Subject: Rezoning Petition Review

Rezoning Petition #: 22-032

Location of Property: Approximately 4.18 acres located on the north side of W Arrowood Rd, east of Forest Point Blvd and west of Nations Ford Rd.

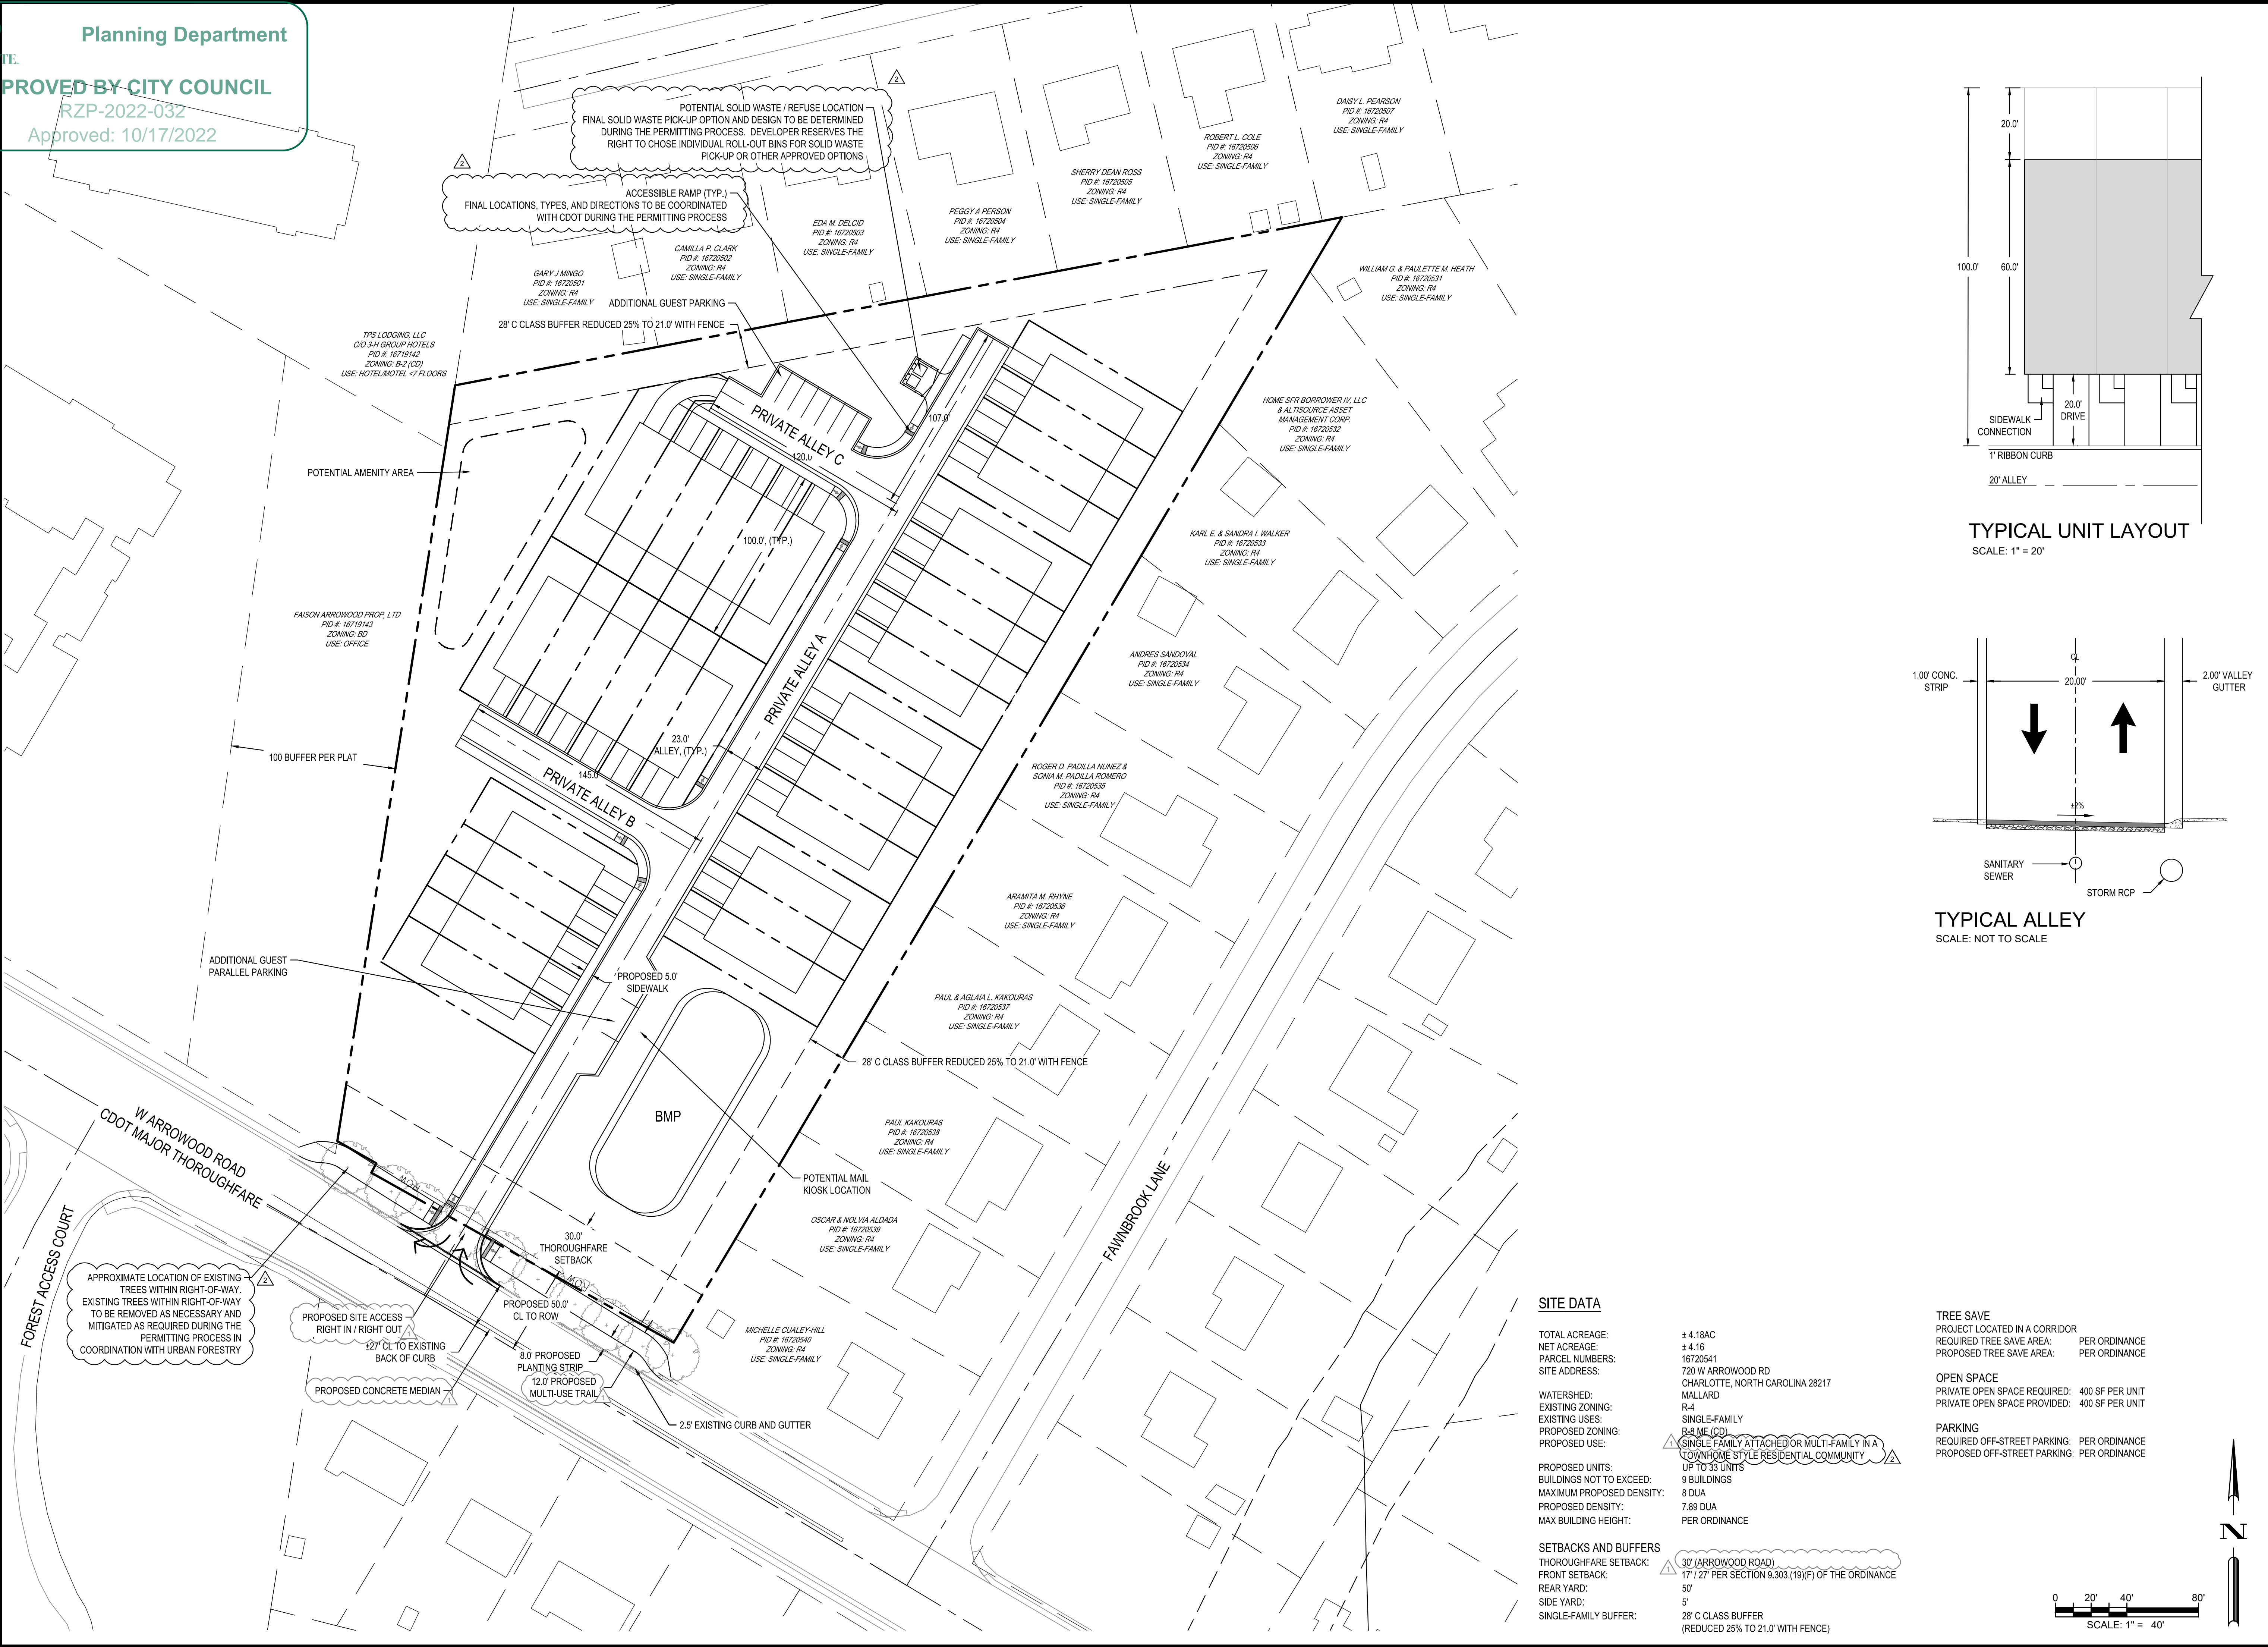
Concerning Storm Water: City of Charlotte GIS indicates a potential drainage feature through the site. Please include the following note under Environmental Features: *“Development within any SWIM/PCSO Buffer shall be coordinated with and subject to approval by Charlotte-Mecklenburg Storm Water Services and mitigated if required by City ordinance. Petitioner acknowledges intermittent/perennial stream delineation reports are subject to review and approval upon submission of development plans for permitting and are not approved with rezoning decisions.”*
